**Date:** 28<sup>TH</sup> January 2011  
**To:** Planning  
**Cc:** -  
**From:** Miriam Hill  
**Subject:** S6/2010/2466/FP – Land adj to 37-48 Lambs Close, Cuffley  
Erection of two semi-detached dwellings following demolition of existing derelict garages.

Site Plan D9

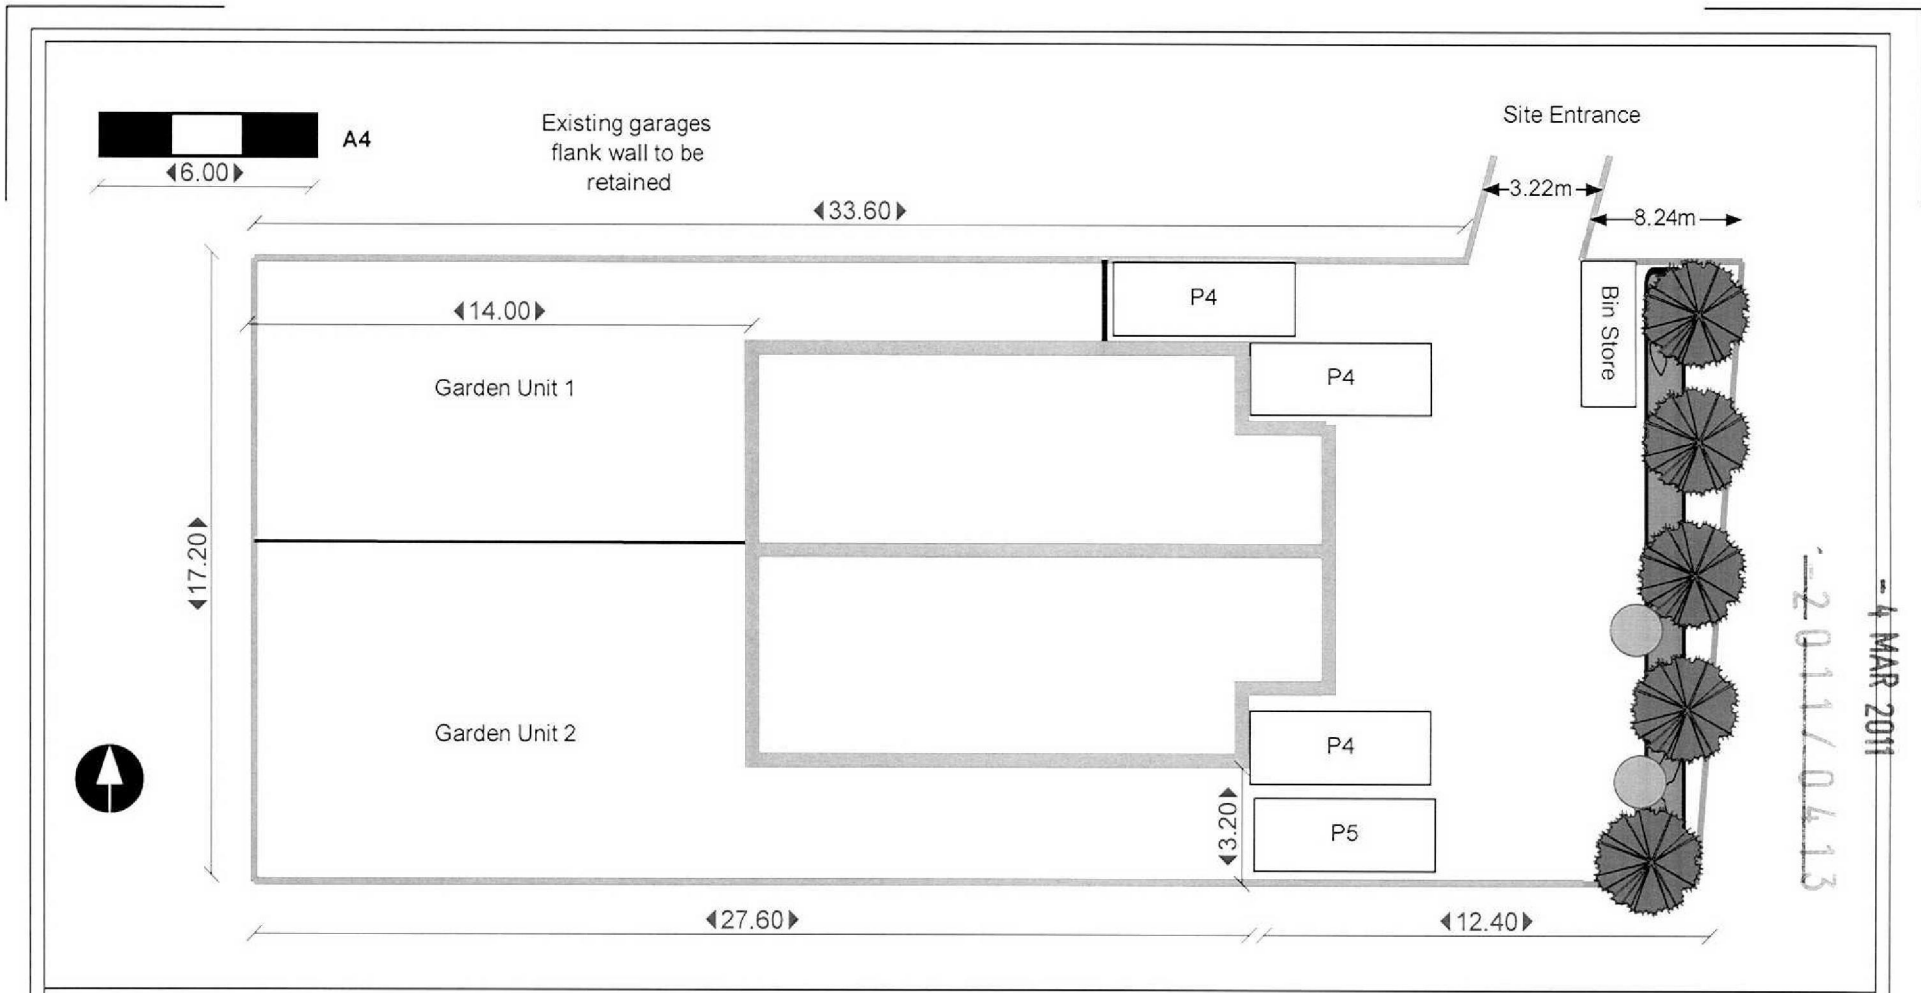
When considering the layout of the site it is more appropriate to use the Tree Survey drawing 2378.D than the Site Layout Including TPO Tree. The latter plan only shows T2 and gives an unrepresentative depiction of the extent of the crown.

My main concern is the future residents living in the shadow of the trees, especially unit 1. Approximately half of unit 1s garden will be directly overhung by the crown. The trees are approximately twice the height of the proposed houses and a gap of less than seven metres is between the drip line of the tree and unit 1. Oaks cast a mid to deep shadow and those living in the shadow of the trees can find them oppressive. In my experience within this borough, most people find they cannot cultivate a reasonable lawn under the trees, nor grow the type of plants they would like to grow. They find the leaf fall in winter unmanageable and the other debris such as honeydew, flowers, acorns, minor shed twigs and caterpillar/bird excrement unacceptable. Many people find tall trees threatening and after unusual weather which causes a small part of the tree to fail, ominous and a great danger to safety. With greater pressure for us all to save energy and the increasing cost

The Method Statement does not discuss any special measures to be taken for the demolition of the garages and forecourt. As the garages are within the root protection area I would expect to have some indication of any special measures required for this site.
